Please ask for: Nicola Moore
Email: nicola.moore@arun.gov.uk
Telephone: Ext 37944
Our Ref: AW/272/21/HH
Your Ref:
Date: 18th August 2021

Application for Planning Permission for Works or Extension to a Dwelling

Development: Conversion of garage to kitchen
Location: 73 Marlborough Court Bognor Regis PO21 5QJ

Drawing No.
3 (22) 00

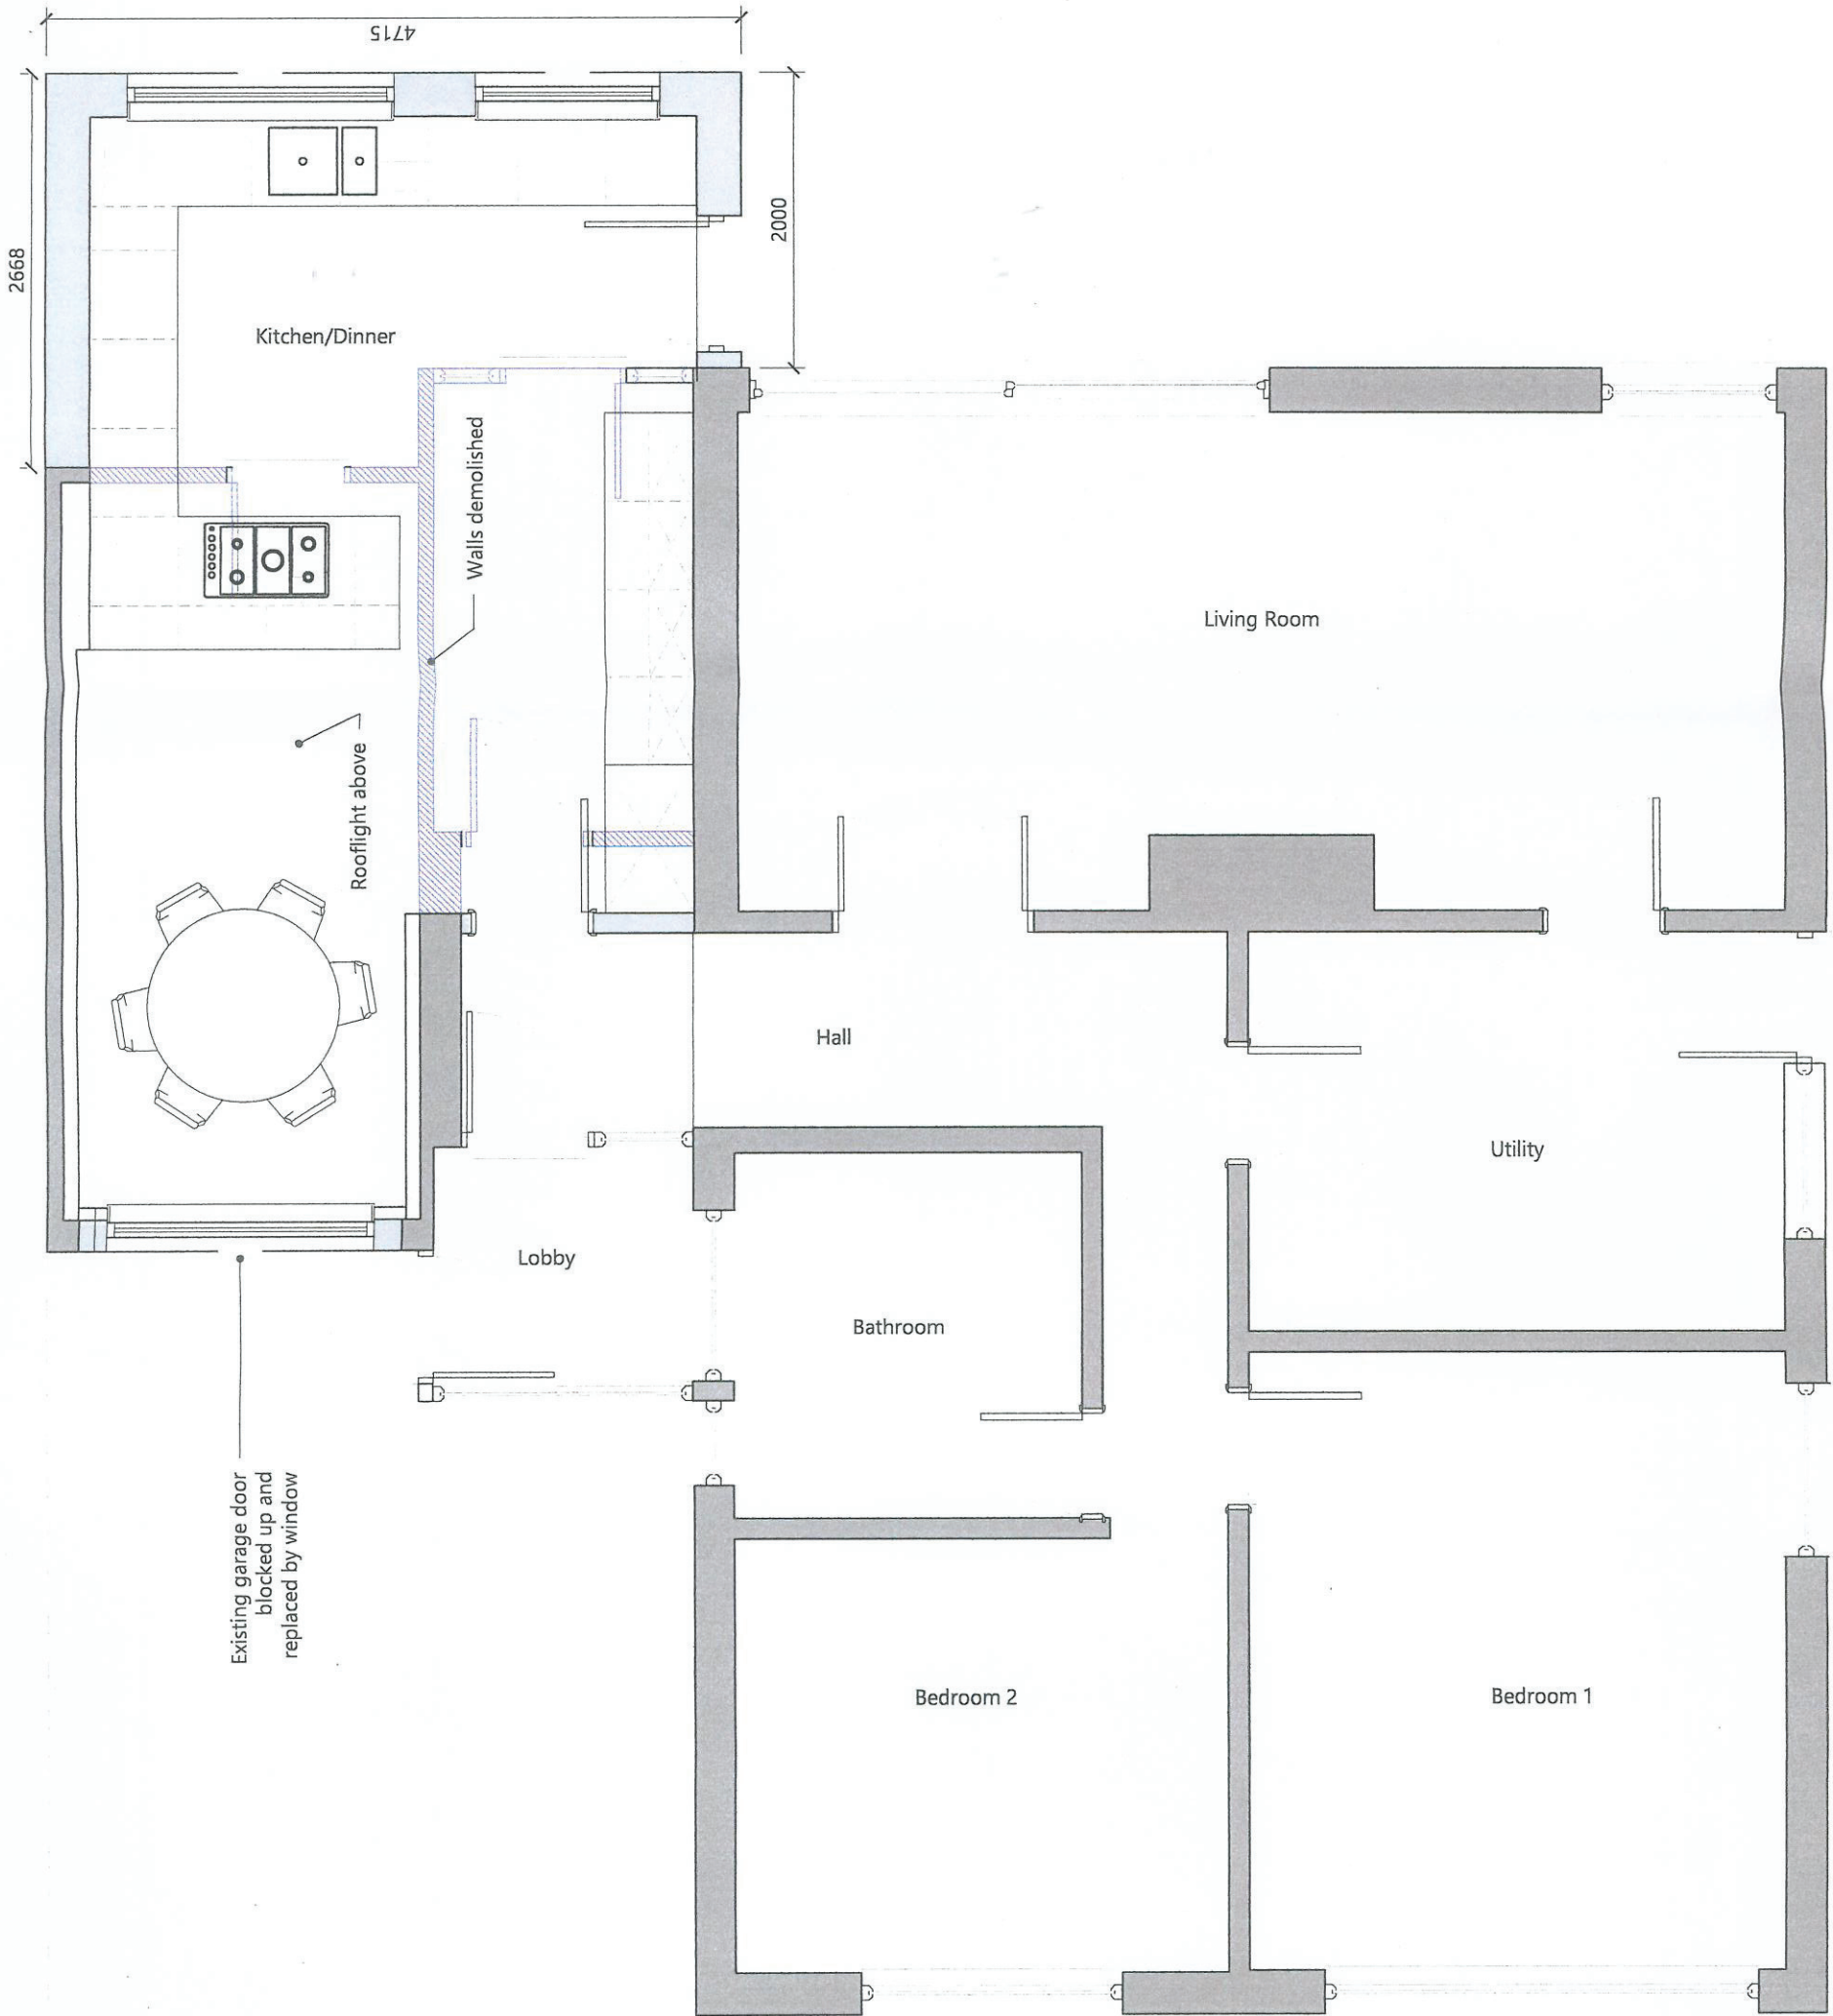
For clarity, please confirm that the plan titled Ground Floor Plan (Dwg No 3 (22) 00) is the Proposed Ground Floor. This can be confirmed in writing.
